Please ask for: Ms Iqraa Malik
Email: iqraa.malik@terraquest.co.uk
Telephone: 01212341390
Our Ref: FP/85/21/HH
Your Ref:
Date: 20th April 2021

Application for Planning Permission for Works or Extension to a Dwelling

Development: Extension to Existing Garage and Garden Room
Location: 55 Limmer Lane Felpham PO22 7HE

DRAWING PLANNING	SCALE 1/100
DATE: MARCH 2021 DRAWN: T. Murray	
DRAWING: 21/27/1	REVISION:

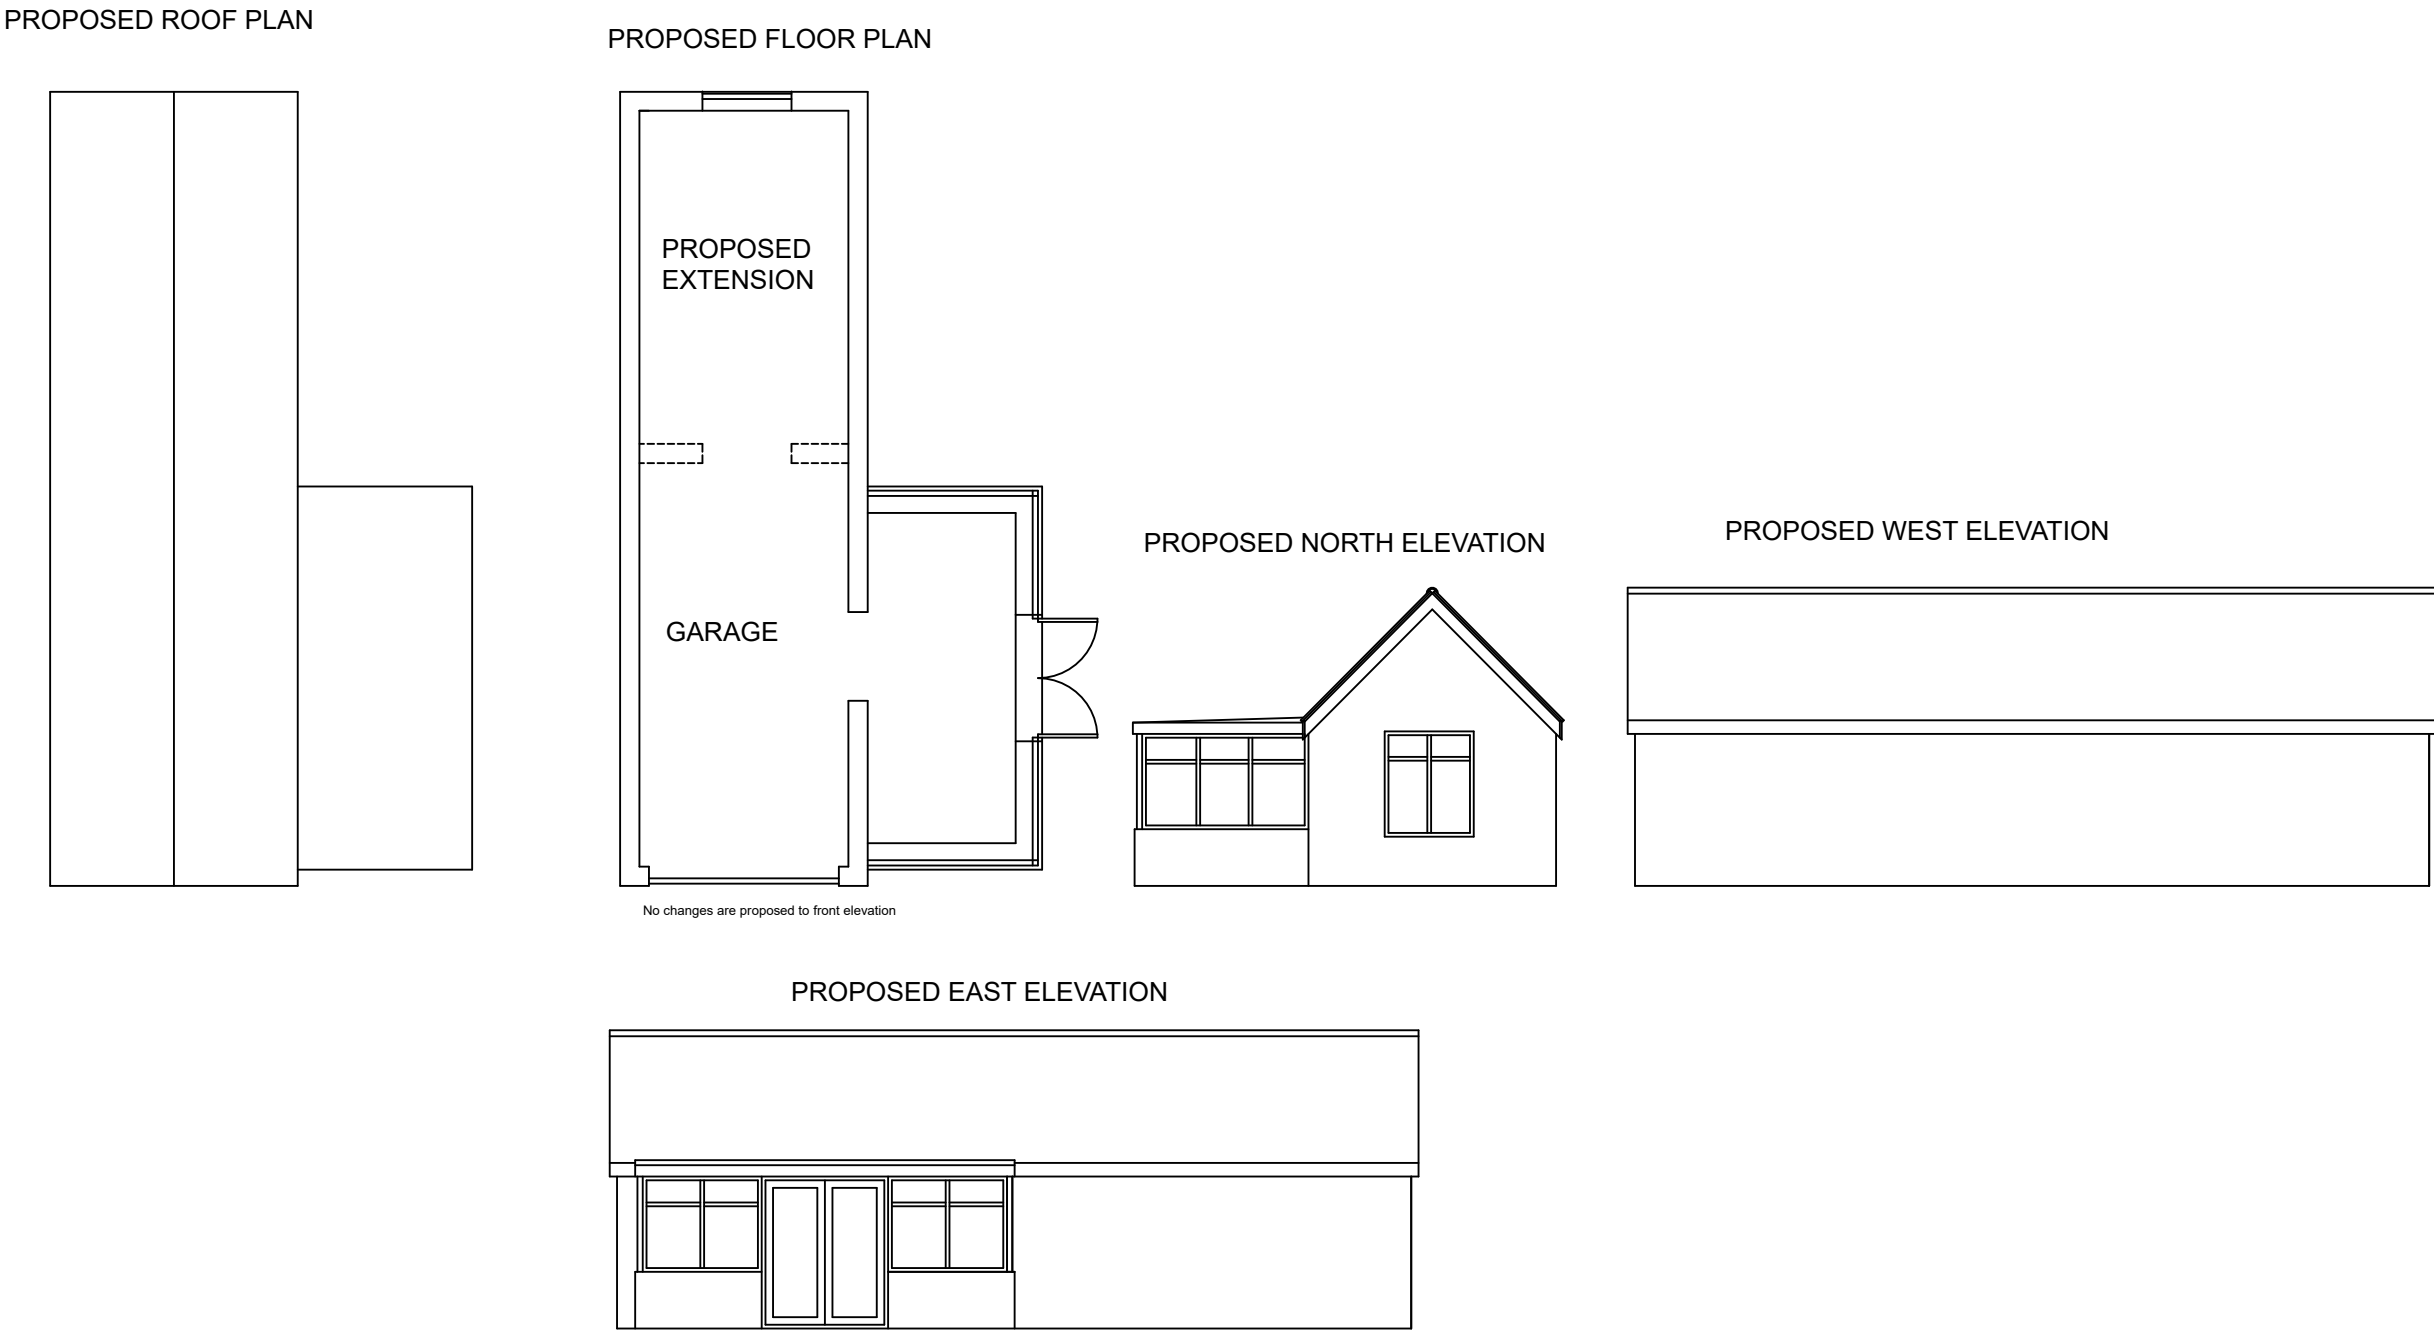
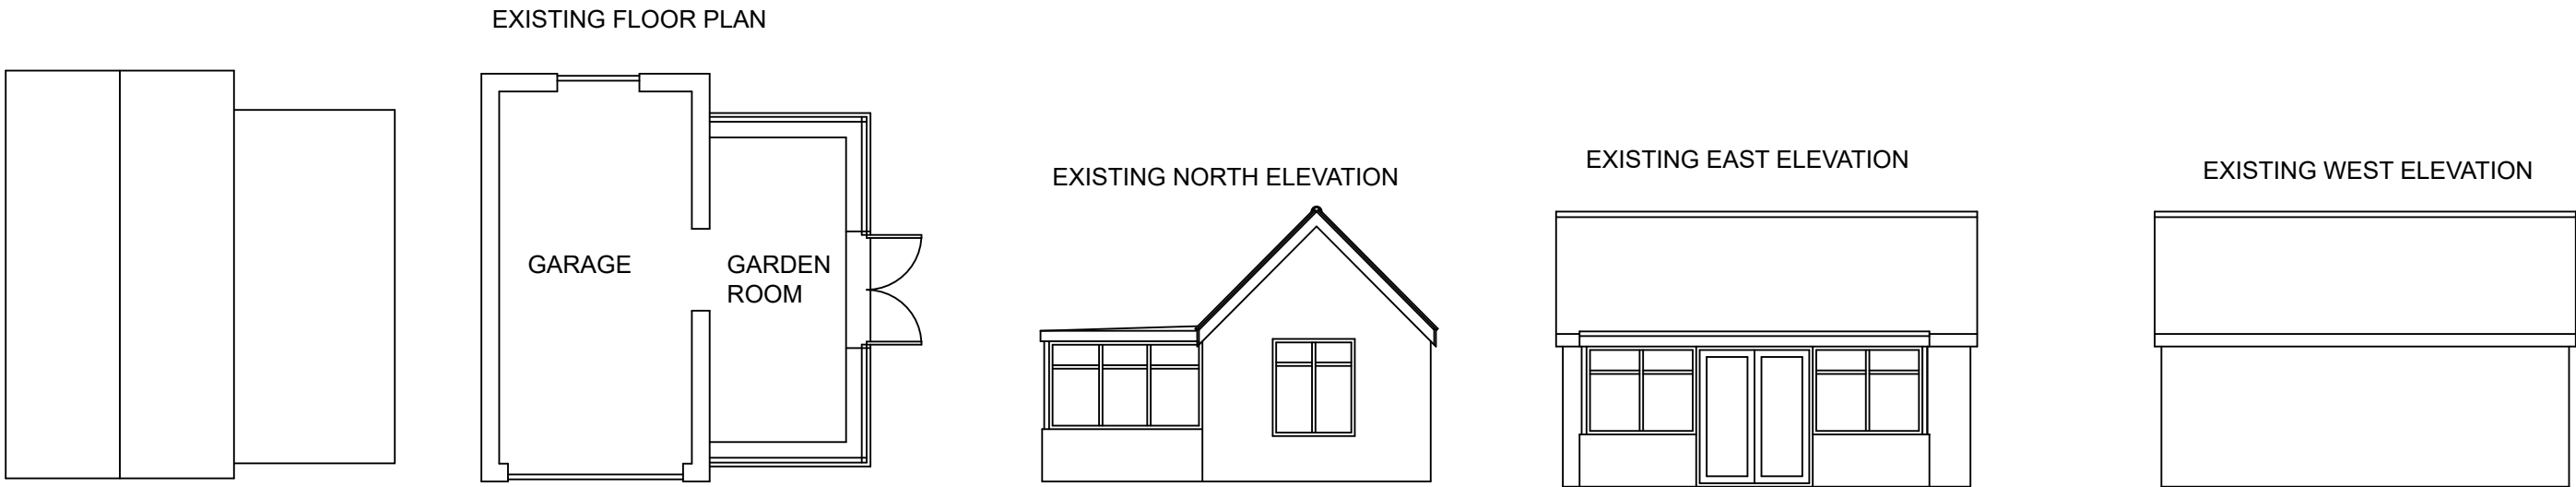
Front Elevation: Please provide a front elevation to show any proposed changes or one to show that no changes are proposed
